From: Cllr Aleks Lukic <Aleks.Lukic@kirklees.gov.uk>
Sent: 08 October 2020 22:49
To: Victor Grayson <Victor.Grayson@kirklees.gov.uk>
Subject: RE: Chidswell planning applications - 2020/92350 and 2020/92331

Please find my comments below for application 2020/92331.

Figure 4-1 Illustrative Masterplan

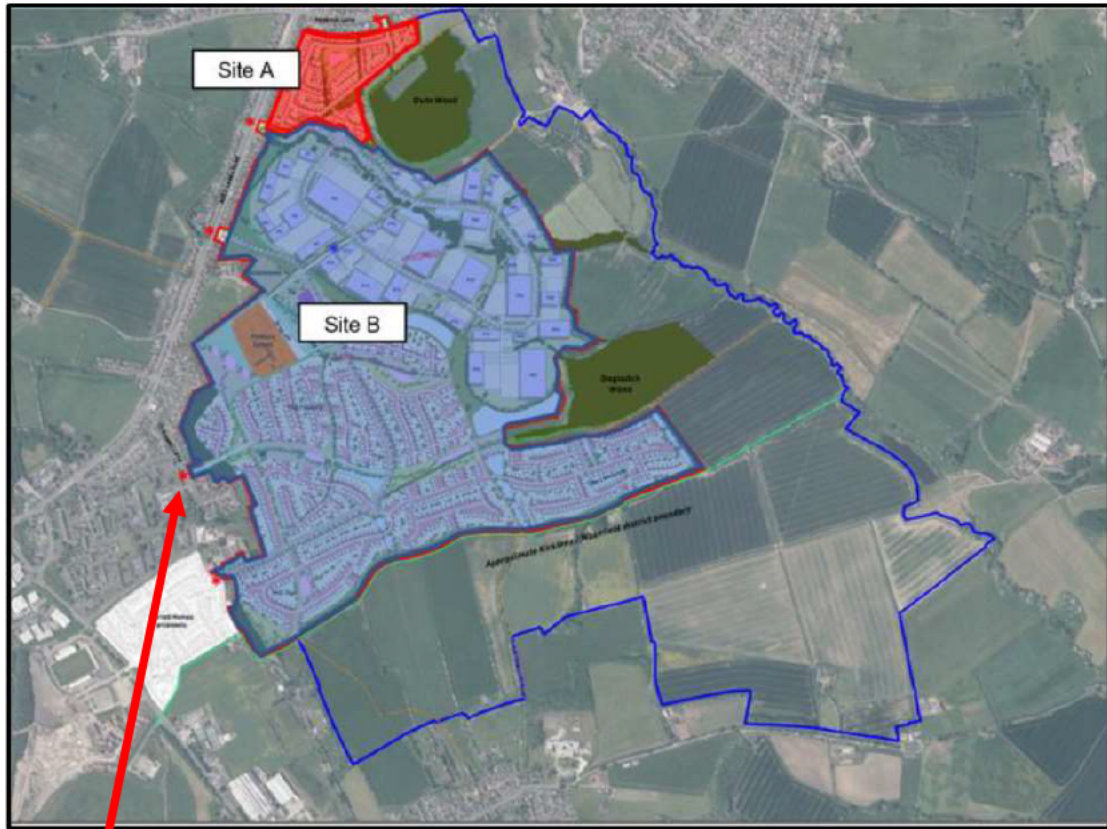
On a specific technical point, the indicative masterplan shows a cycle route adjacent to Dogloitch Wood but this is not contained within the red line boundary of the application. There is an existing public right of way along that line but this does not currently allow for cycling. The red line boundary should include all indicated components of the proposed scheme so that the committee knows exactly what they are deciding on.
